WEST SUSSEX COUNTY COUNCIL CONSULTATION

TO:	Arun District Council FAO:Mr Z Denton
FROM:	WSCC - Highways Authority
DATE:	25 September 2020
LOCATION:	61 Worthing Road Rustington BN16 3JU
SUBJECT:	R/142/20/HH Dropped kerb for off road parking at front of property.
DATE OF SITE VISIT:	n/a
RECOMMENDATION:	More Information
S106 CONTRIBUTION TOTAL:	n/a

61 WORTHING ROAD

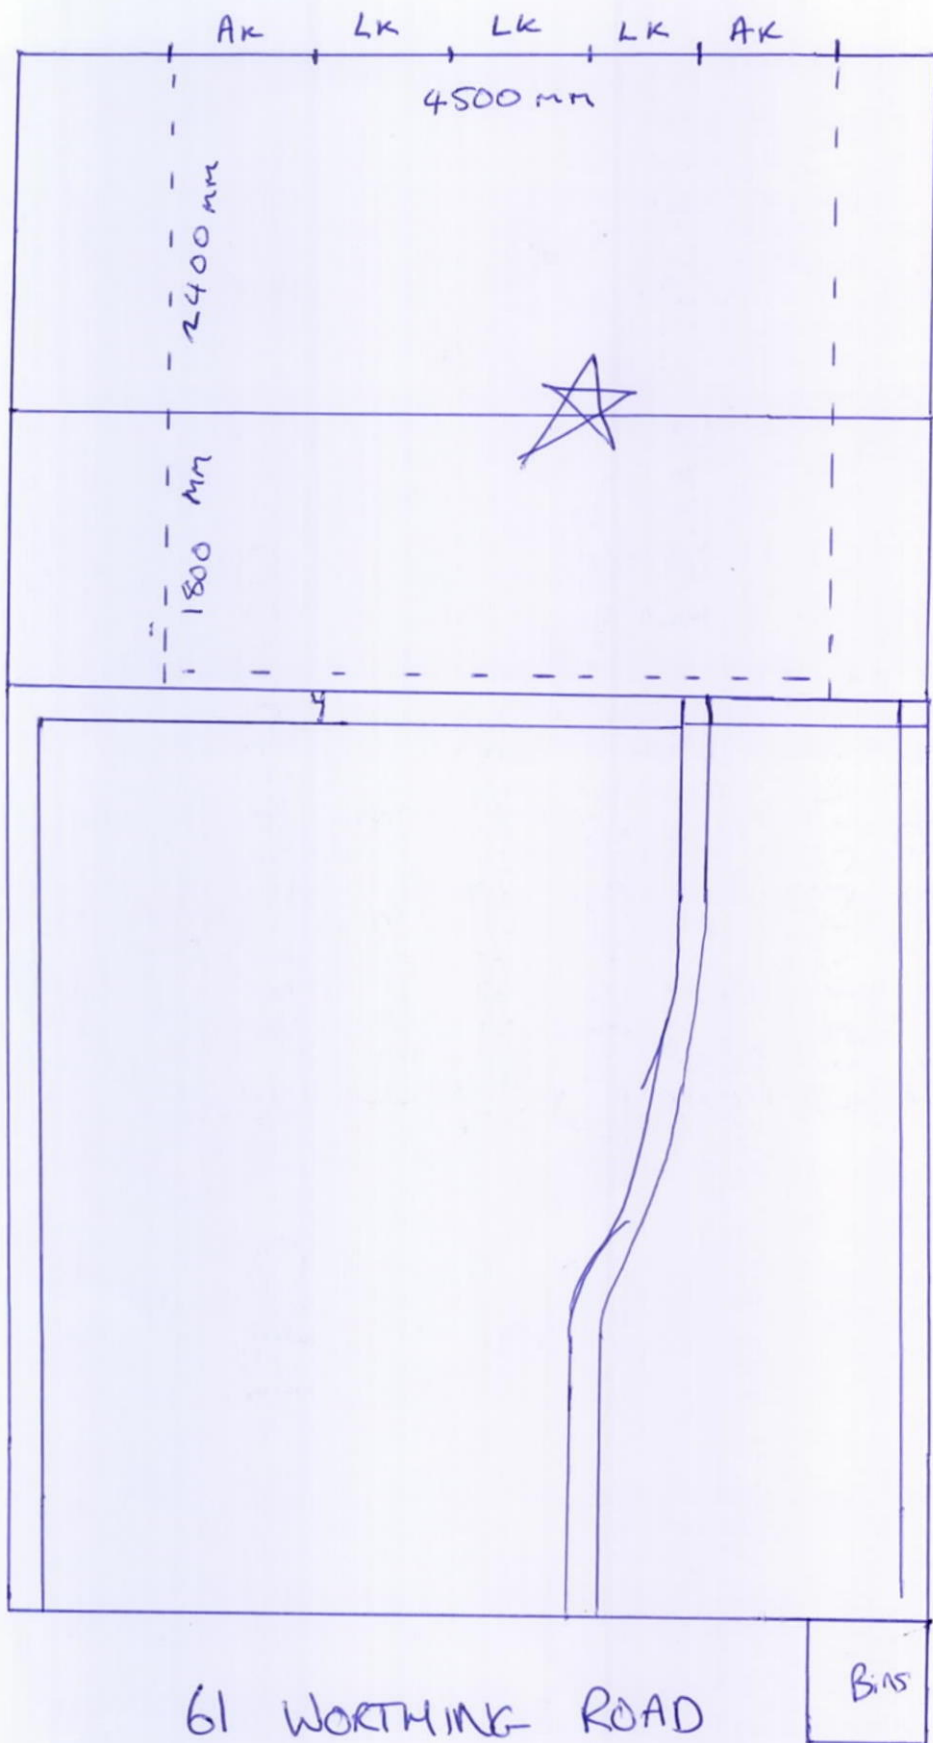
The applicant has demonstrated visibility splays at the proposed access. The plan annotates visibility splays of 43m in each direction, however I note that the plan scale does not show correct measurements. Our Local mapping indicates that splays of 43m are achievable in each direction and wholly maintained within highways land.

The proposed VCO, as demonstrated on the proposed plan is approximately 4.5m wide. Any access works within the public highway must be implemented under licence obtained by WSCC Highways to a specification agreed with them.

The proposed driveway measures circa 4.5 x 4.1m. The minimum requirements for single parking bay is 2.4m x 4.8 m as outlined in Manual for Streets (MfS) guidance. The proposed parking area does not meet these specifications; however, this could be improved based on revised plan extending the driveway. The applicant is requested to provide details of this on a set, correctly scaled plan.
